Your ref: 22.0553  
Our ref: D3.22.0553  
Date: 26<sup>th</sup> August 2022

**App no: 22.0553**

**Address: Higher College Farm Lower Road Longridge**

**Proposal: Proposed erection of mixed-use commercial units including conversion and extension of farmhouse to Use Class E (b) (c) (d) (e) (f) (g) and Sui Generis (Health and Beauty).**

6 4 7 8 - 0 5 G

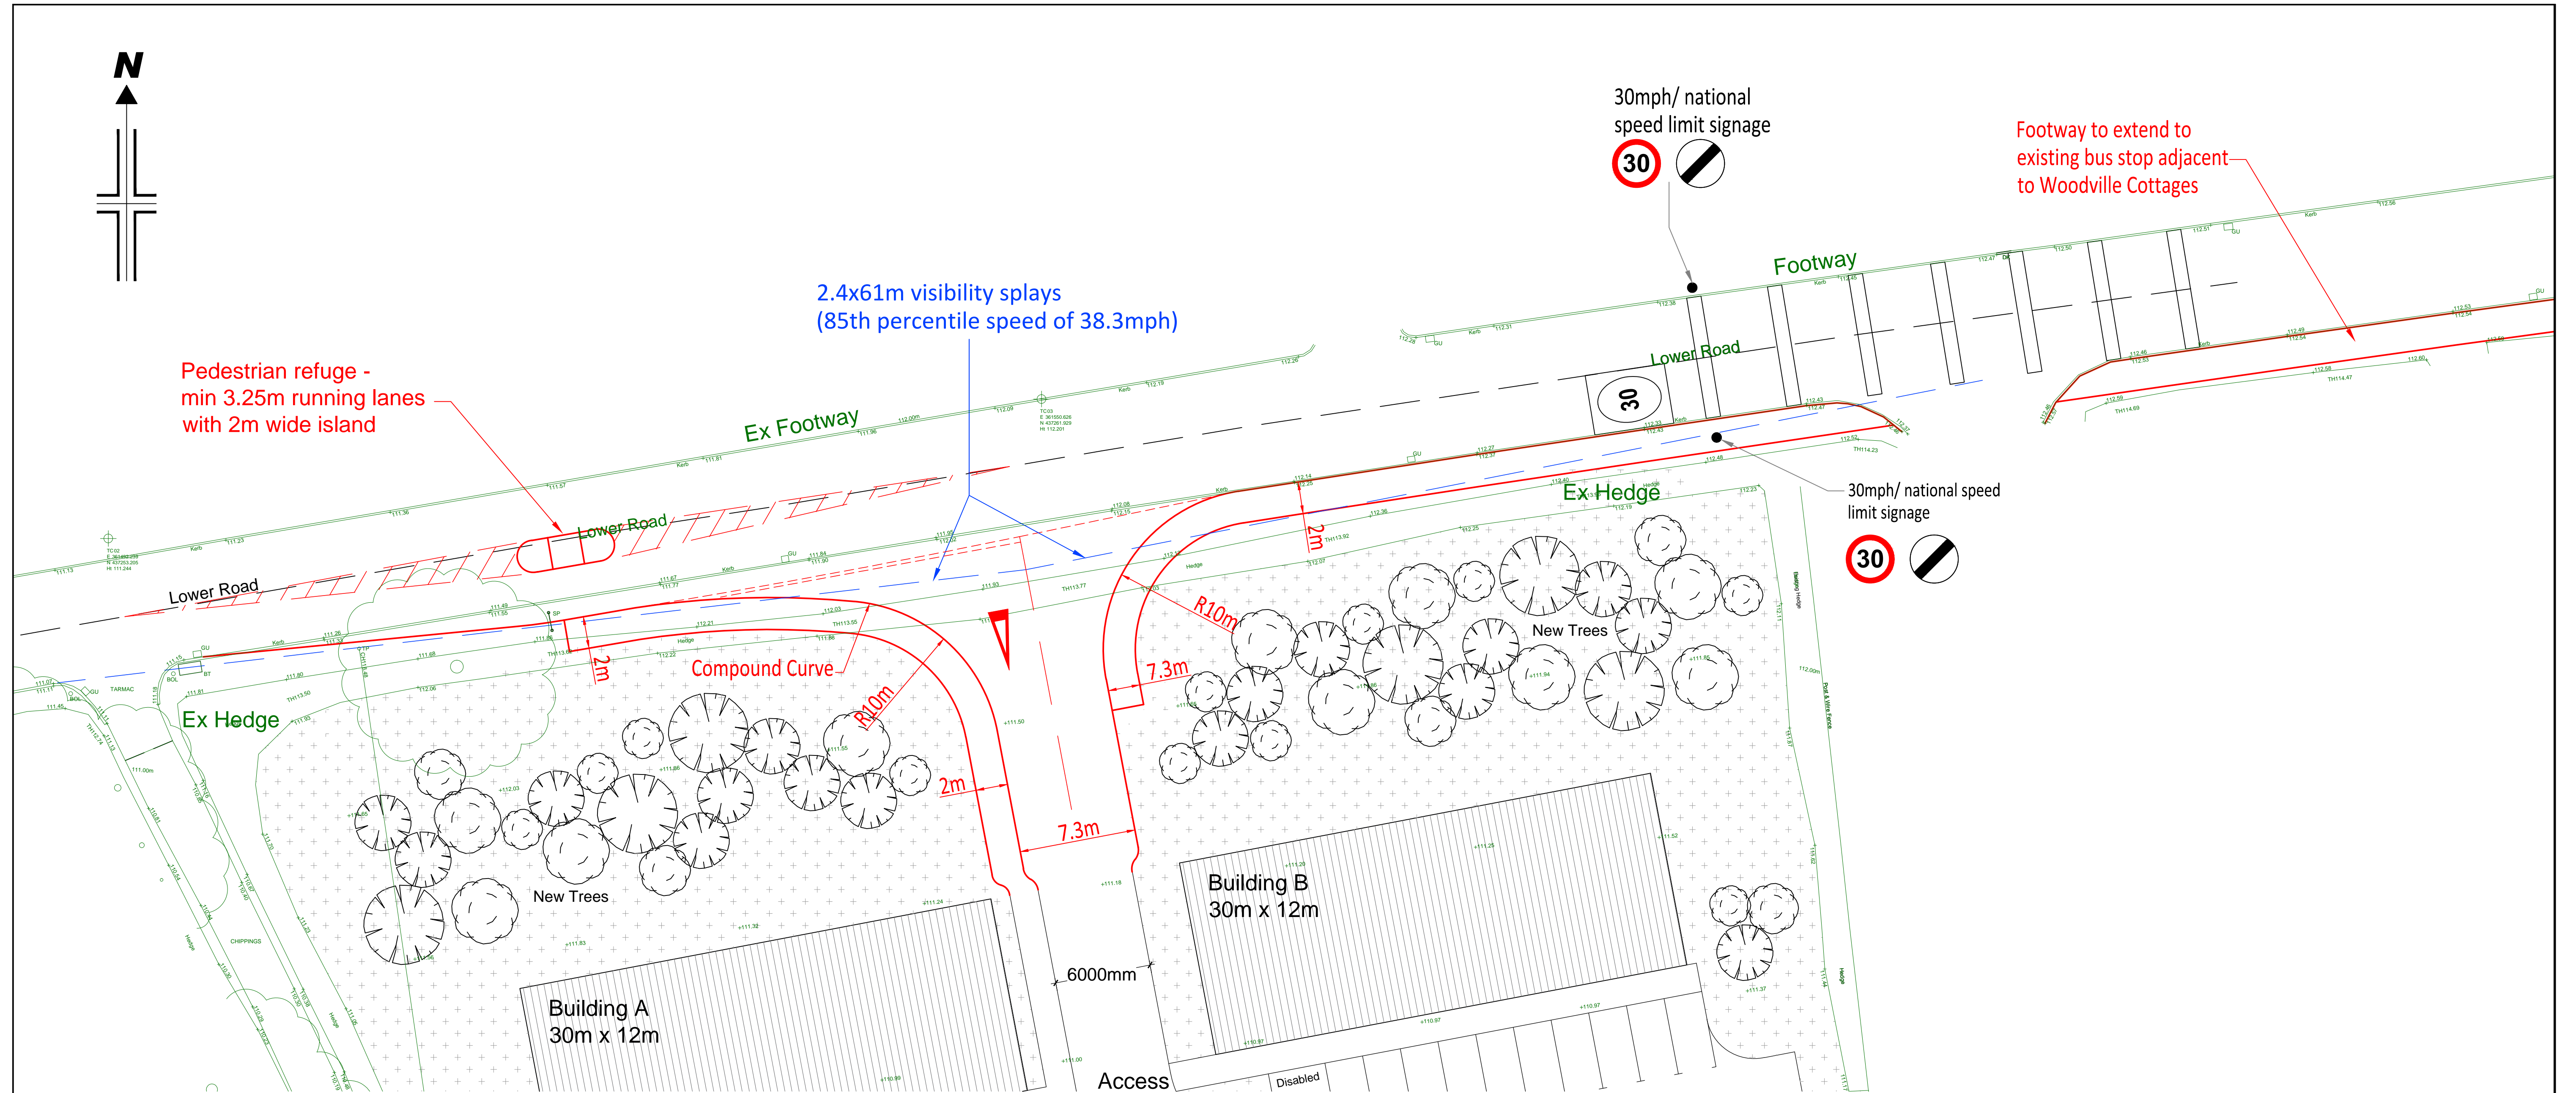
Additional swept path analysis is requested to show the refuse wagon accessing the bin stores.

The site access junction Lower Lane is tracked for a 16.5m articulated vehicle however this has not been extended to include the internal layout. This needs to be submitted to demonstrate that the internal layout can accommodate this size of vehicle. It is noted that the B8 element of the scheme has been removed and therefore it is unlikely that articulated vehicles will be delivering to the site, however this needs to be clarified to avoid any confusion for future operators.

There are no designated areas for the loading/unloading of goods and the plans are unclear if each unit will have a roller shutter door to allow a goods vehicle to load goods directly into the building. The end users are unknown, therefore details of the type/frequency of delivery goods vehicles cannot be submitted. A Delivery Management Strategy should be submitted once the end users are known unless further details can be submitted at this stage to clarify the demands for goods vehicles.

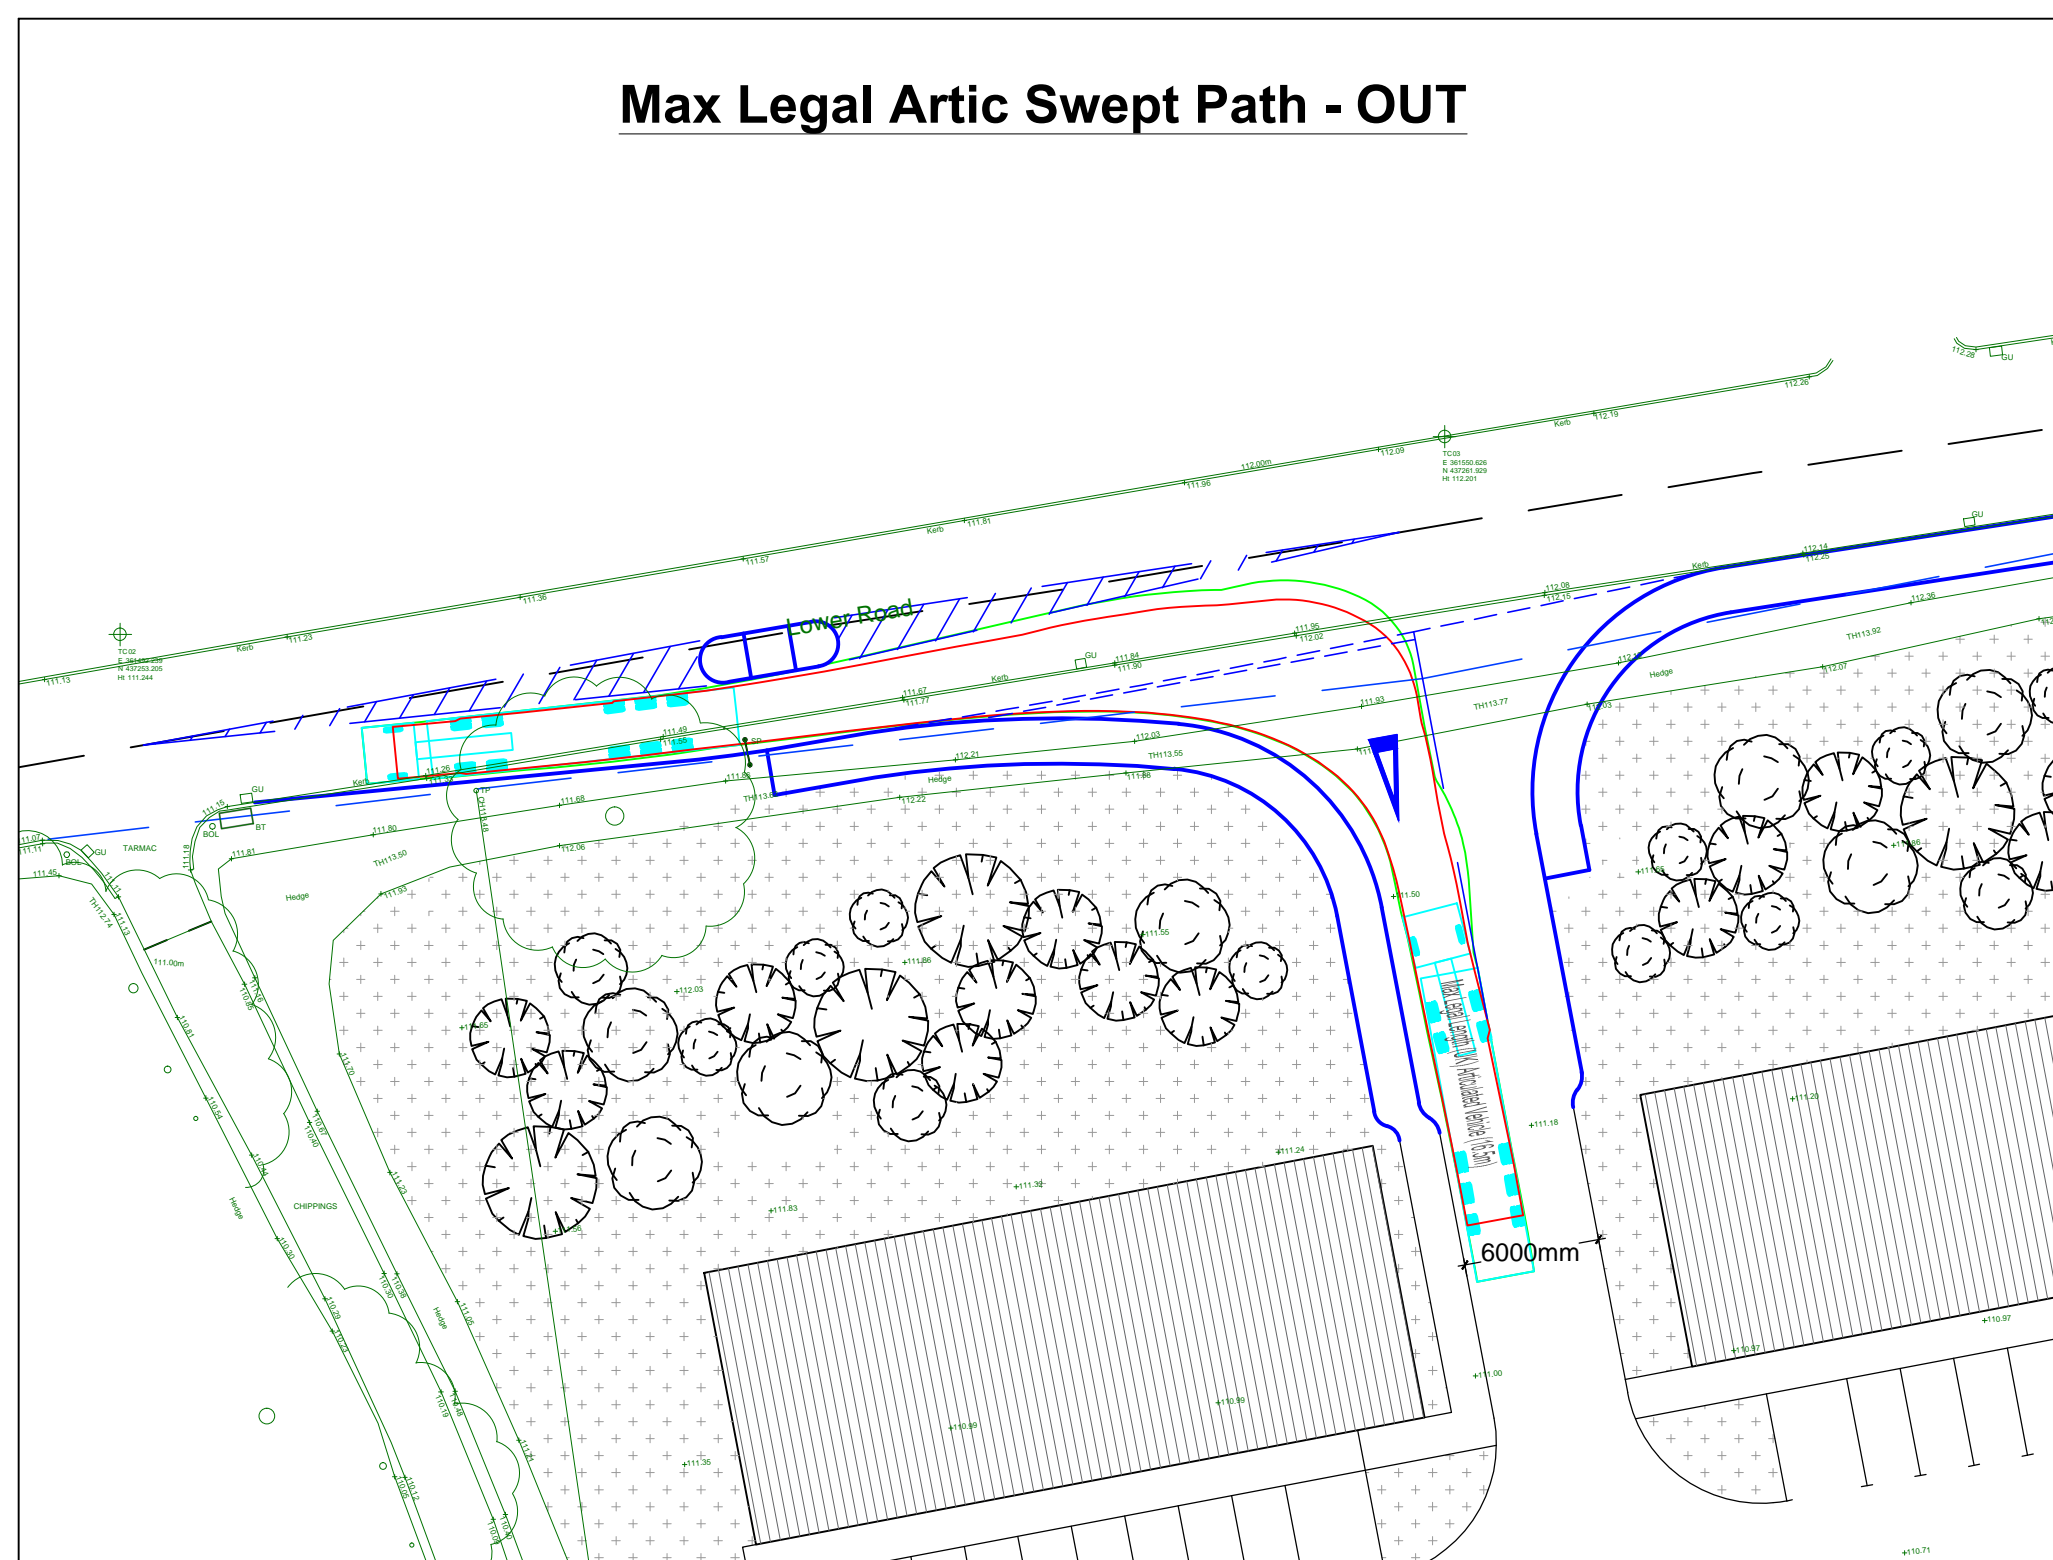
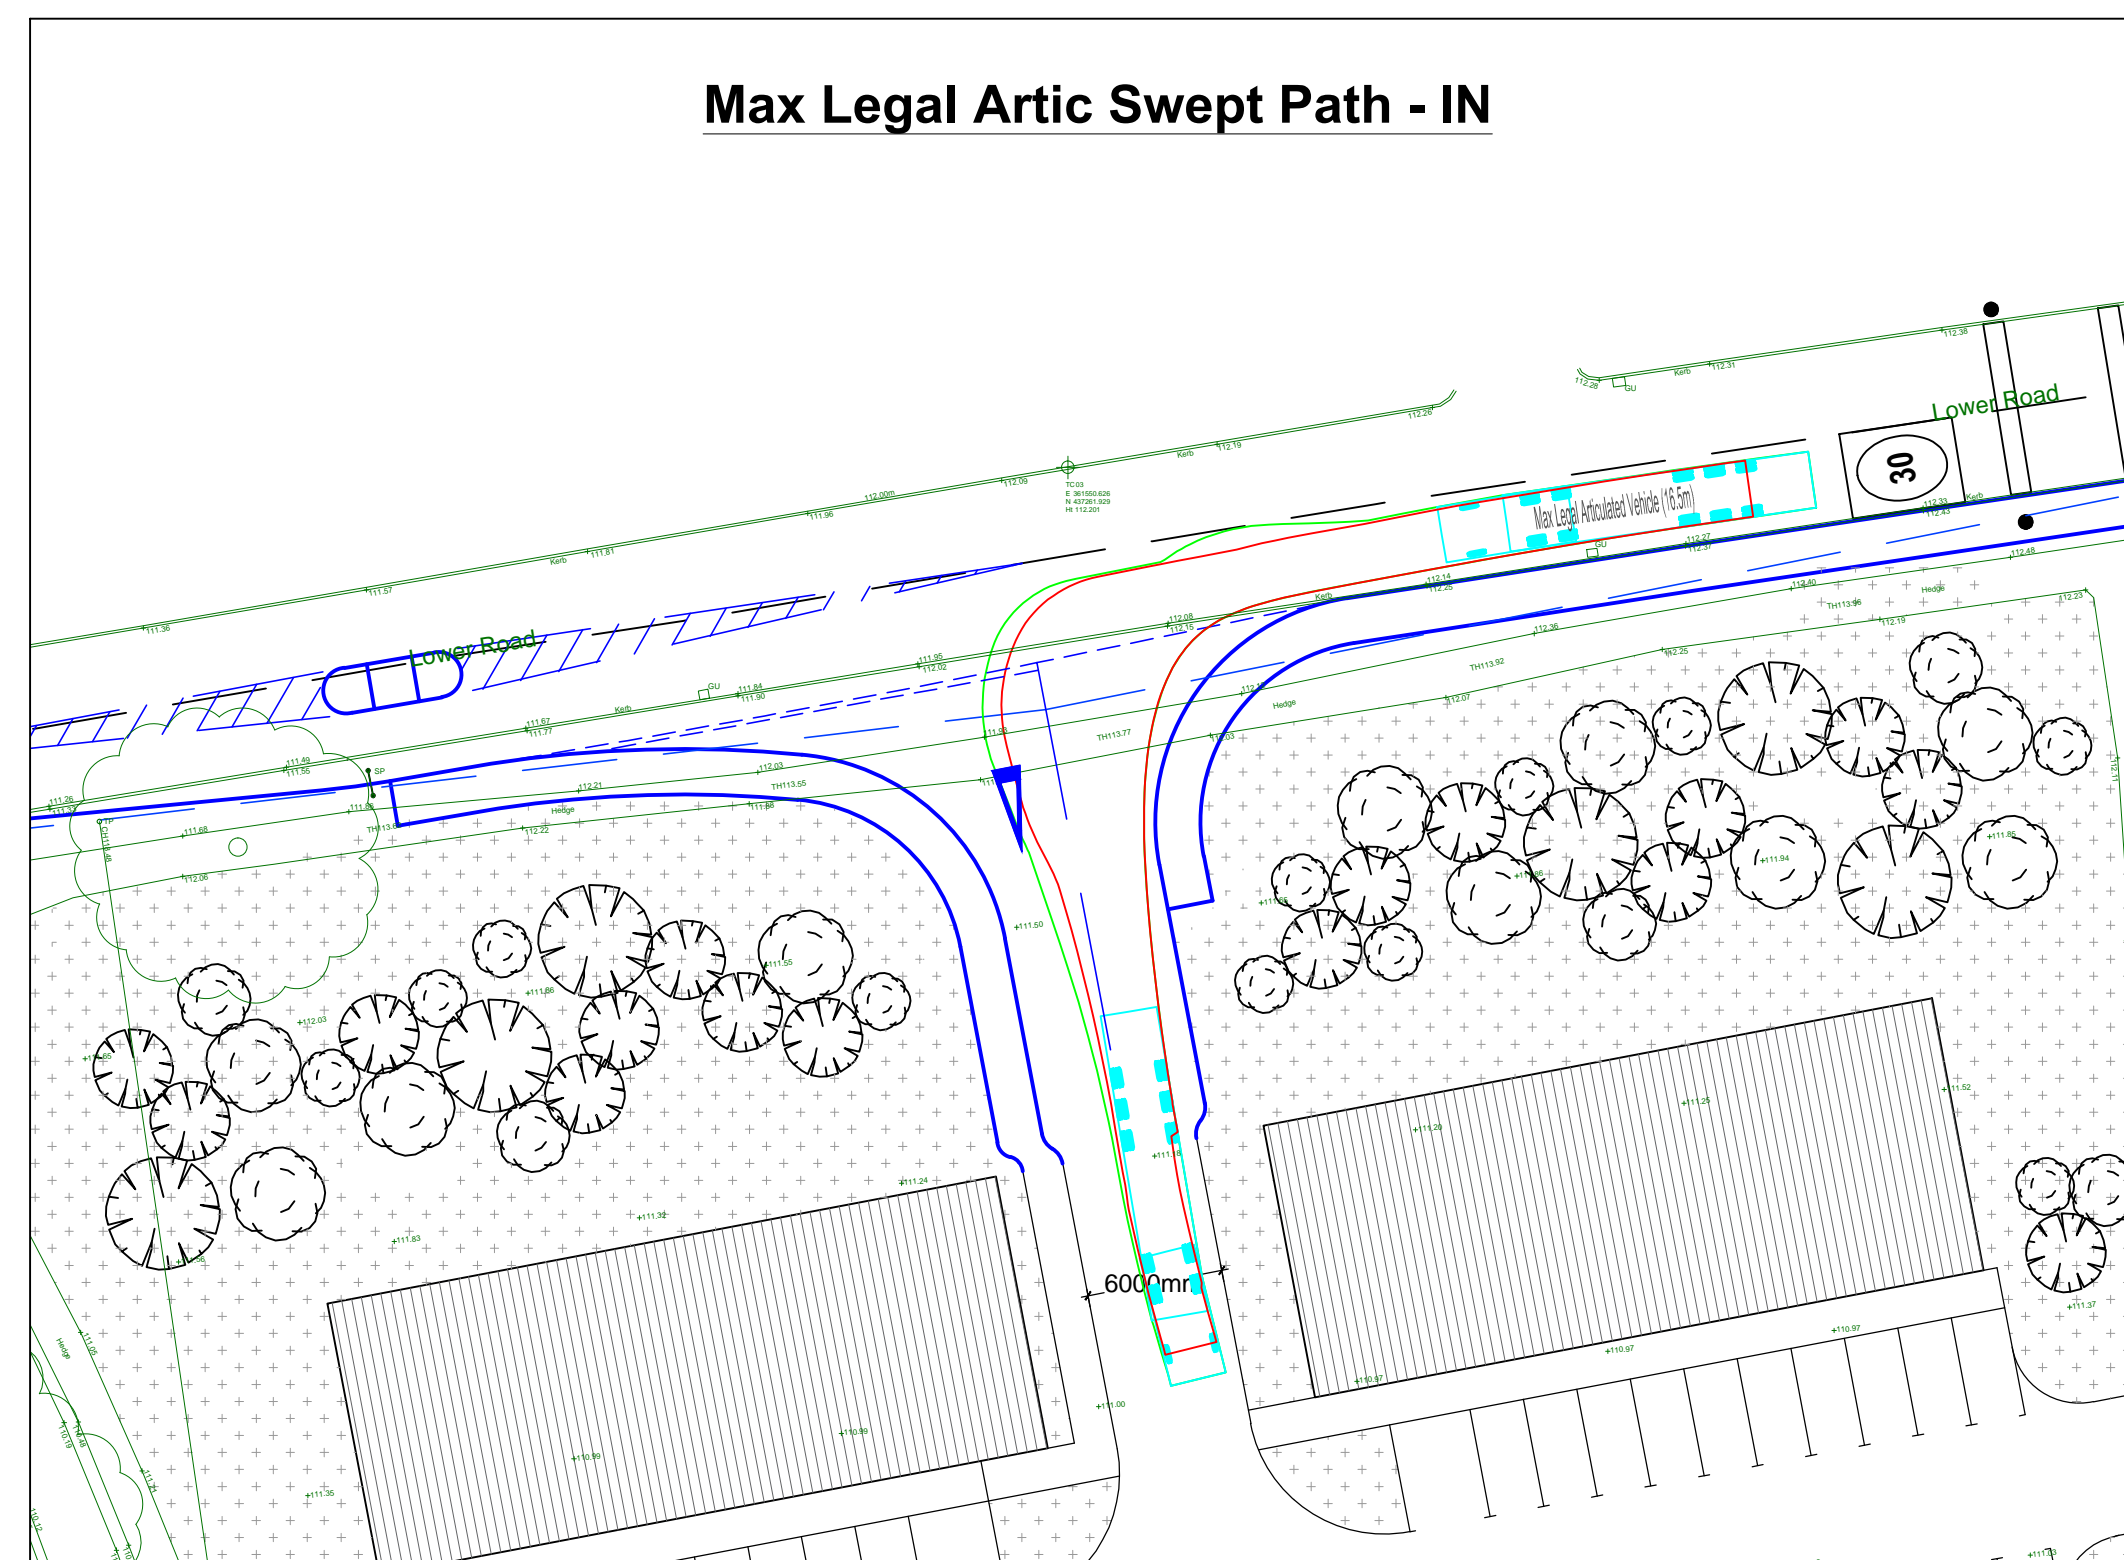
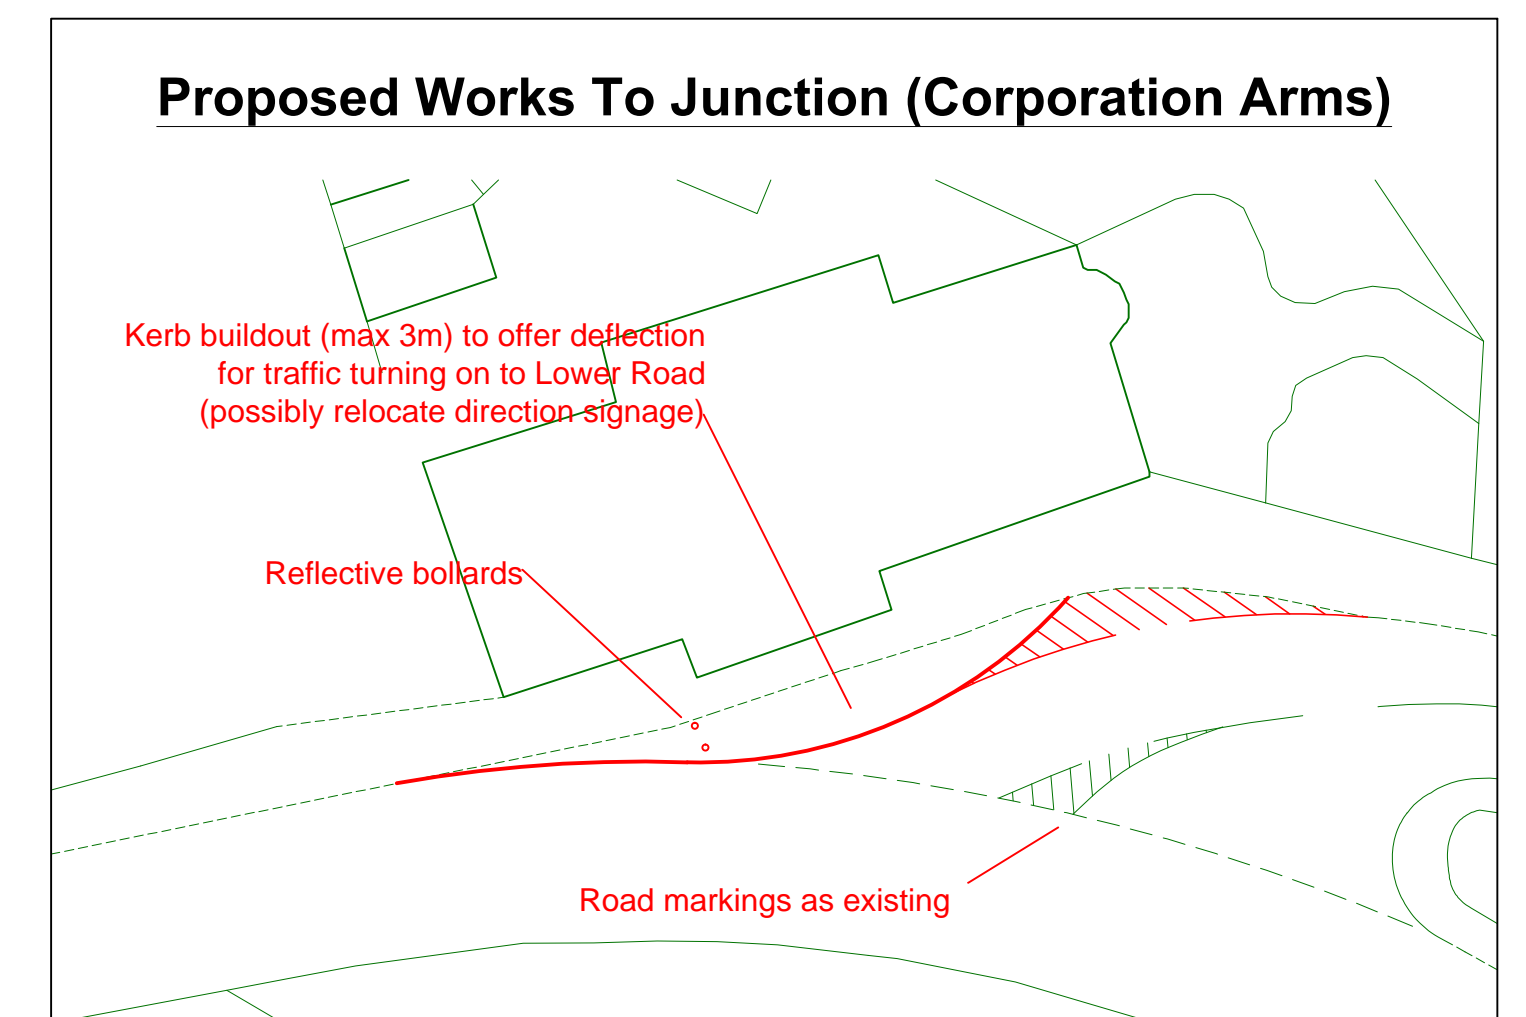
The previously approved drawing PSA Design H2683-01 Rev A dated Nov 2017 is submitted for this application and is deemed suitable to accommodate the development traffic.

The new access will serve the whole development and will need to be constructed prior to the works commencing on site.

The existing access on Lower Lane will remain open to serve the field accesses. The Transport Statement confirms that a gateway will be installed to separate the existing access from the development site. We do not support the intensification of use of the existing access due to sub standard geometry and visibility splays.
